Your Ref :
Our Ref : BE/126/17/NMA

Non-material amendment following a grant of planning permission BE/94/17/HH relating to moving the west facing wall away from the boundary
65 Van Gogh Place, Bersted, ,

Item#	Quantity	Title/Name, designation, material, dimension etc		Article No./Reference
Designed by	Checked by	Approved by - date	Filename	Date
65 Van Gogh Place	XXX			July 2017
Proposed Rear Extension				Scale
				1:50
				02
				Edition
				0
				Sheet
				1/1

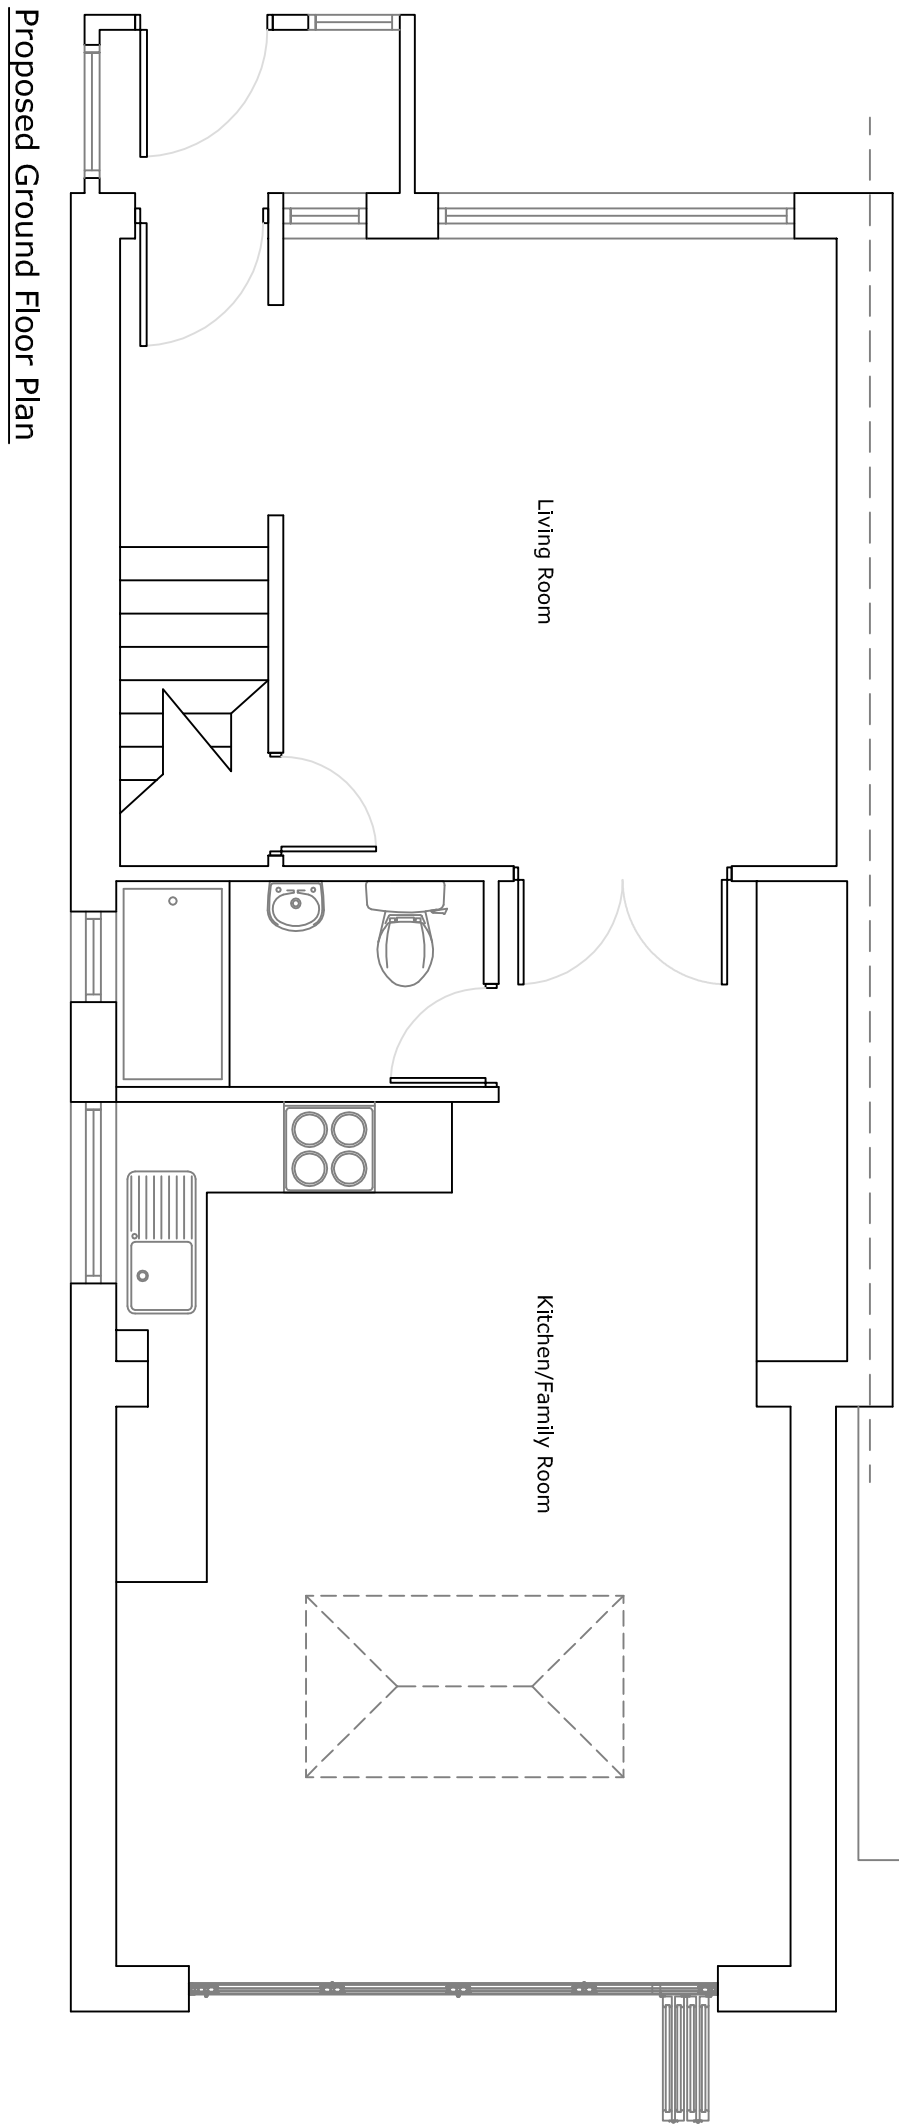
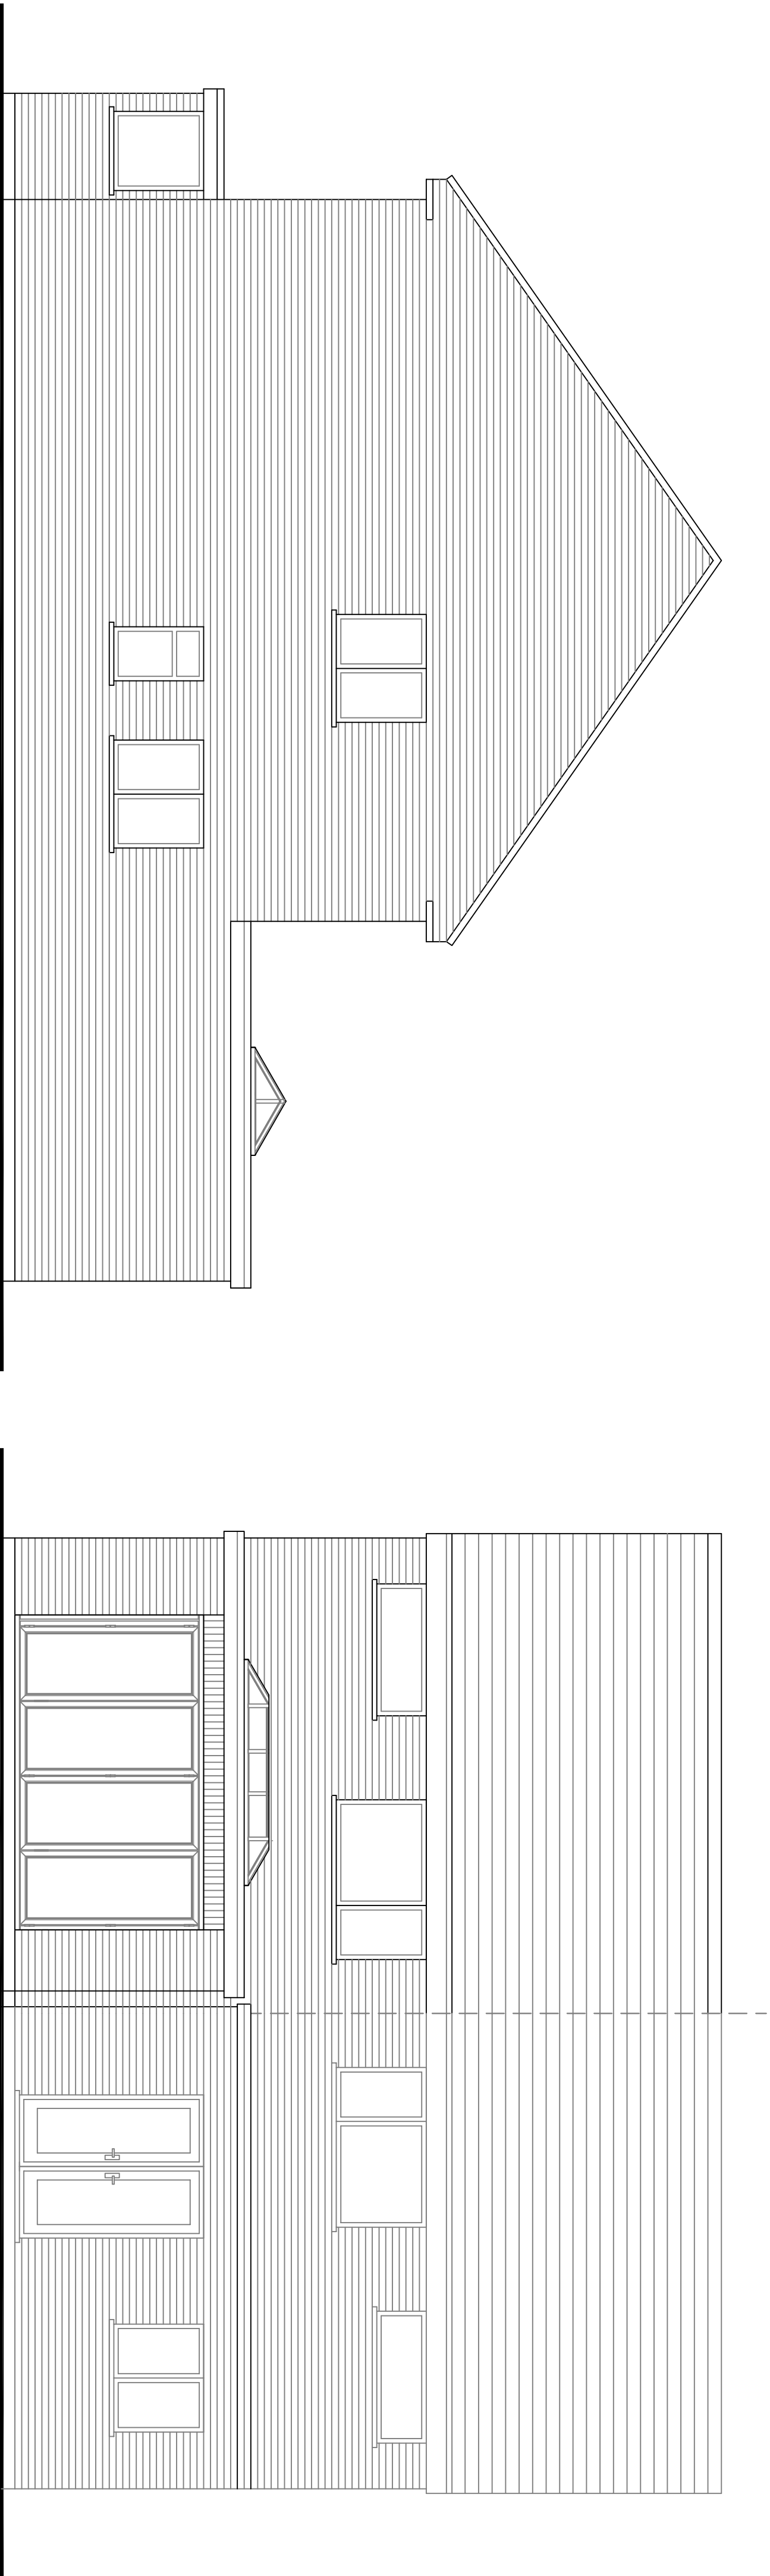
I refer to your recent application for a Non Material Amendment to move the west facing wall of the extension away from the boundary. From the information submitted I am able to take the alterations as a non material amendment and the following plans become the approve plans for BE/94/17/HH:

02 Edition 02 Sheet 1/1
